TO: Dusty Pilkington, Community Development Services  
FROM: Kelly Bacon, Engineer Technician I *KB*  
DATE: April 20, 2018  
SUBJECT: Galloway BL-17-00024

The Public Works Department has reviewed the Request for Boundary Line Adjustment. **Our department recommends preliminary approval with the following conditions:**

PRELIMINARY BOUNDARY LINE ADJUSTMENT EXHIBIT		
PREPARED FOR UNIONVILLE RANCH, LLC A PORTION OF SECTIONS 5 AND 6, TOWNSHIP 19 NORTH, RANGE 17 EAST, W.M.		
KITTITAS COUNTY	WASHINGTON	
DWN BY DLP/GW	DATE 11/2017	JOB NO. 141361
CHKD BY GW	SCALE 1" = 200"	SHEET 1 OF 1

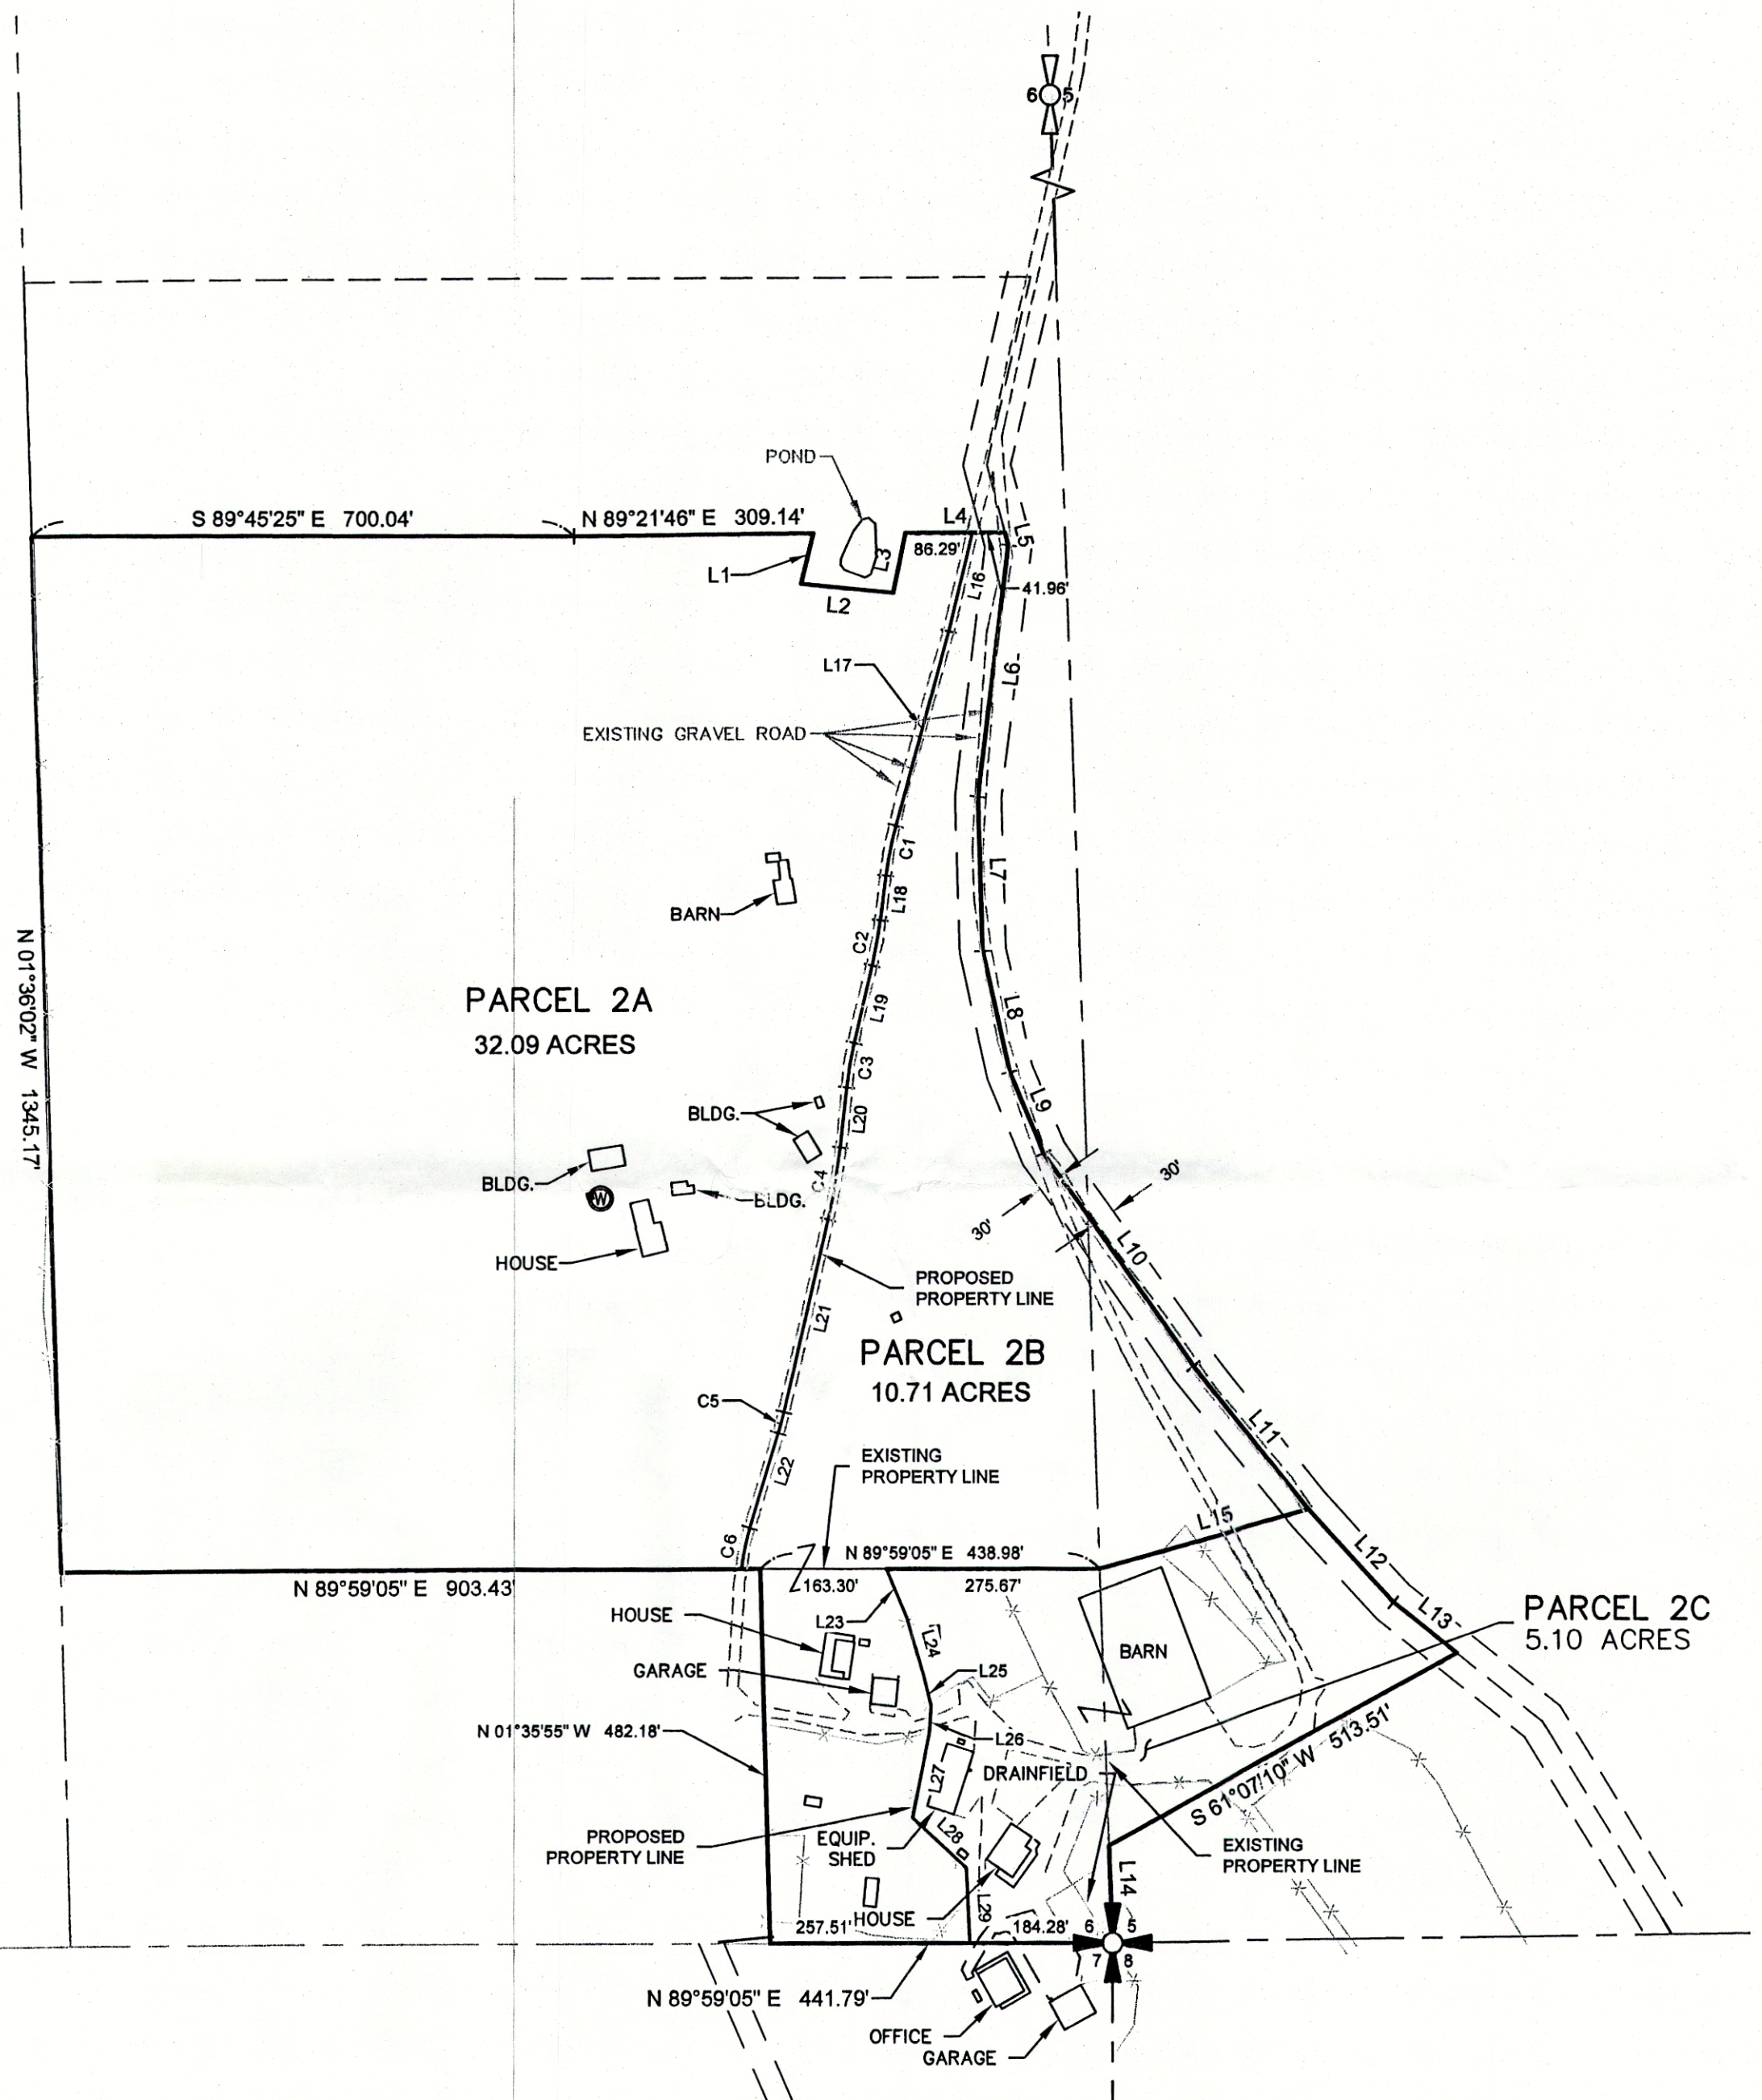
- a. Existing gravel road at the east boundary of 2A shall be a 60 foot dedicated easement and meet current Kittitas County Road Standards dated 12/15/15 for a Private Road with Average Lot Size > 10.0 Acres.

- b. A private road certification is required prior to final approval.
- c. Show access easements to all tax parcels.
- d. An approved access permit shall be required from the Kittitas County Department of Public Works prior to creating any new driveway access or performing any work within the county road right of way.
